February 4, 2026

RE: Response to WDFW Comments on RU-25-00004 Thomas
Parcel186635, Kittitas County, Washington
SWC Job #24-117

*Above: Mapping of the south OHWM (blue line) of the Type F stream and its associated 150' buffer (yellow line) on the site. The existing clearing is defined by gps points 506-521 (points 511 & 512 are errors).*

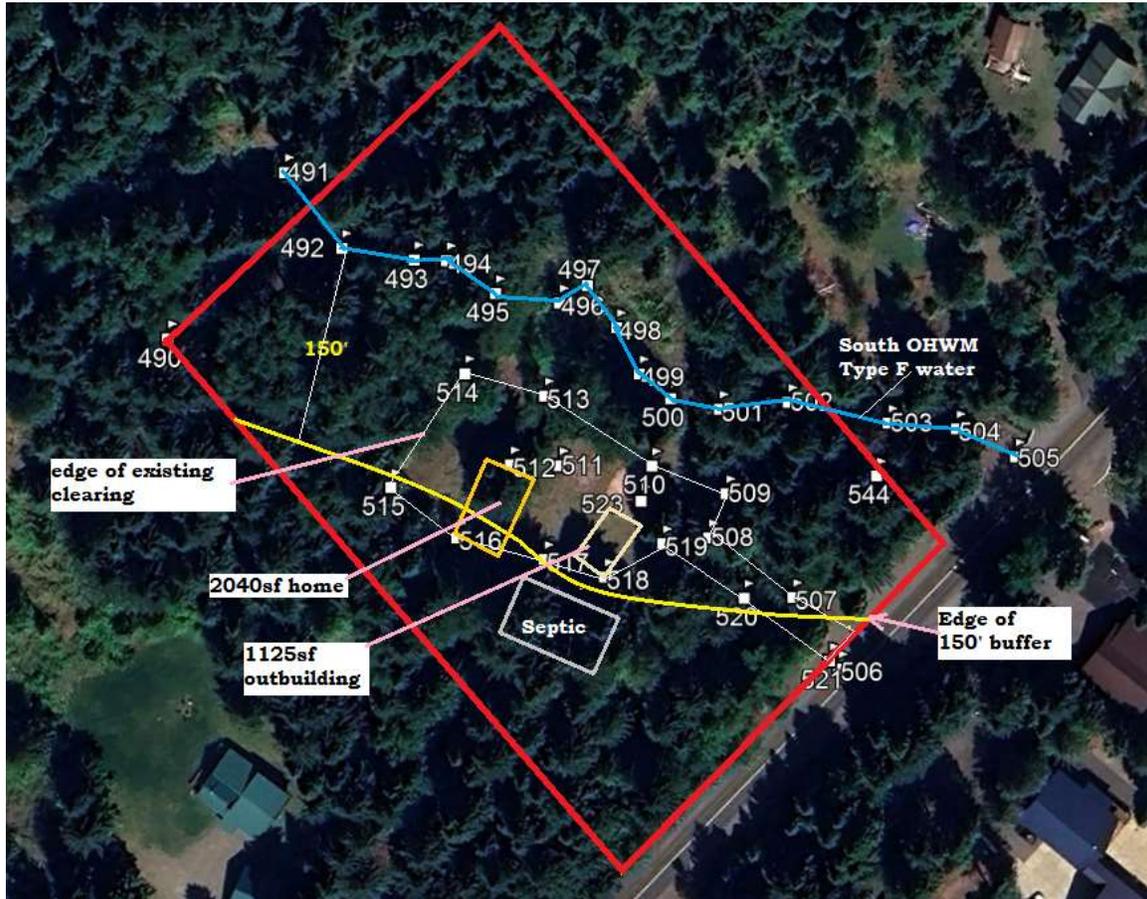
The WDFW letter implies that the buffer would be 100' or the SPTH whichever is greater. Using their latest tree height data the letter stated that 212' was the tallest based upon the possibility of western white pine being present.

I have inspected the site and area around the site and there is no western white pine present. I have travelled much of the area and logging roads around this area of Lake Kachess for years (as I live in this area of the County) and the presence of western white pine in this area is generally rare, and none was observed in this area.

The site has douglas fir, mountain hemlock and black cottonwood. The letter states the SPTH for Douglas fir s 148', in line with the 150' buffer we utilized and which appears more appropriate.

Above: Proposed site plan with added buffer as mitigation for buffer impacts.

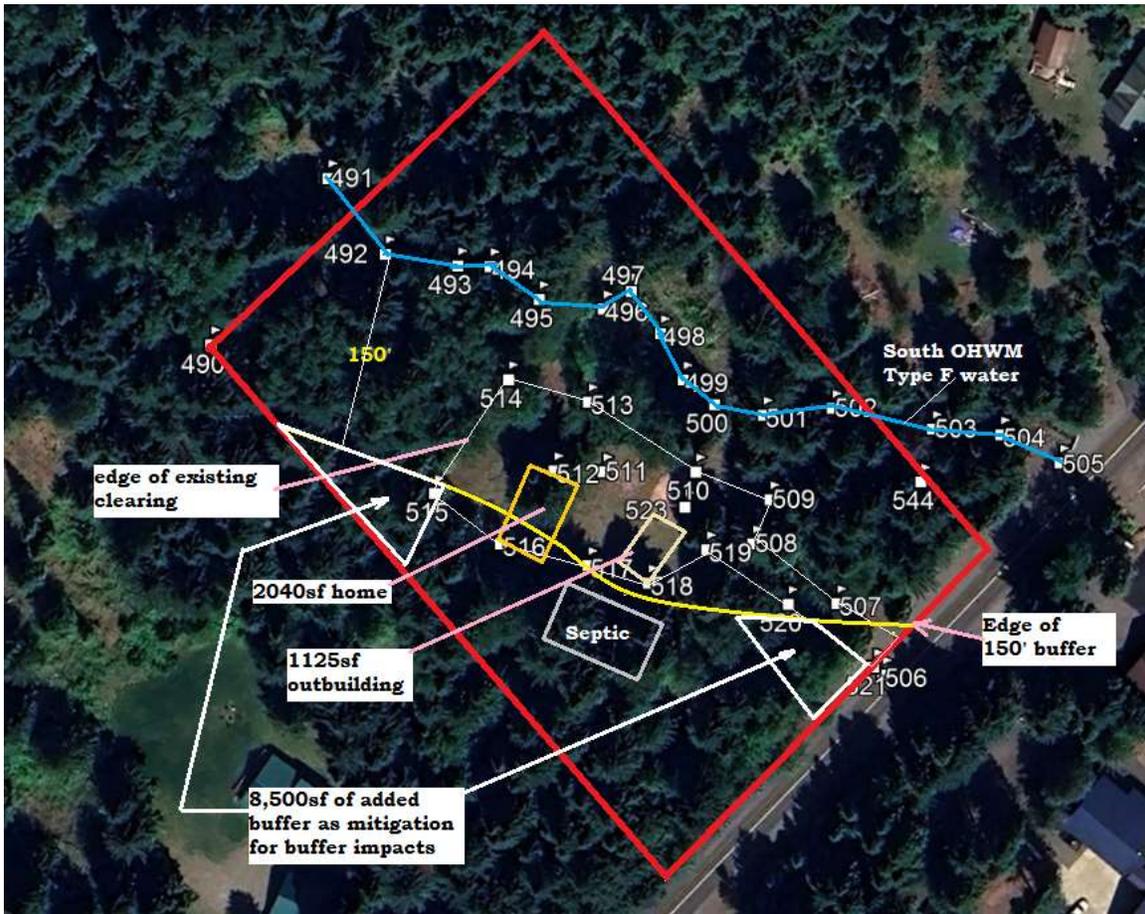
The letter stated that WDFW did not see a plan showing where the buffer will be added. This was included in our July 15, 2025 CAR on page 15 clearly showing the added areas. We have included that image below from the originally submitted CAR. Since they did not review our proposed added buffer areas they were unaware we were showing the added buffer areas as mitigation for any functional buffer impacts to the Type F stream.

We believe the justification and proposed added buffer area at a 1:1 ratio for the new home will mitigate any impacts as the detailed by the code requirements.

At this point we do not believe a “mitigation plan” with plantings is required to mitigate any buffer function impacts that are not being addressed by the added forested buffer areas for this project. The proposed buffer enhancement will result in no net loss of buffer function to the stream, will increase tree cover to the Type F stream, and utilizes best available science.
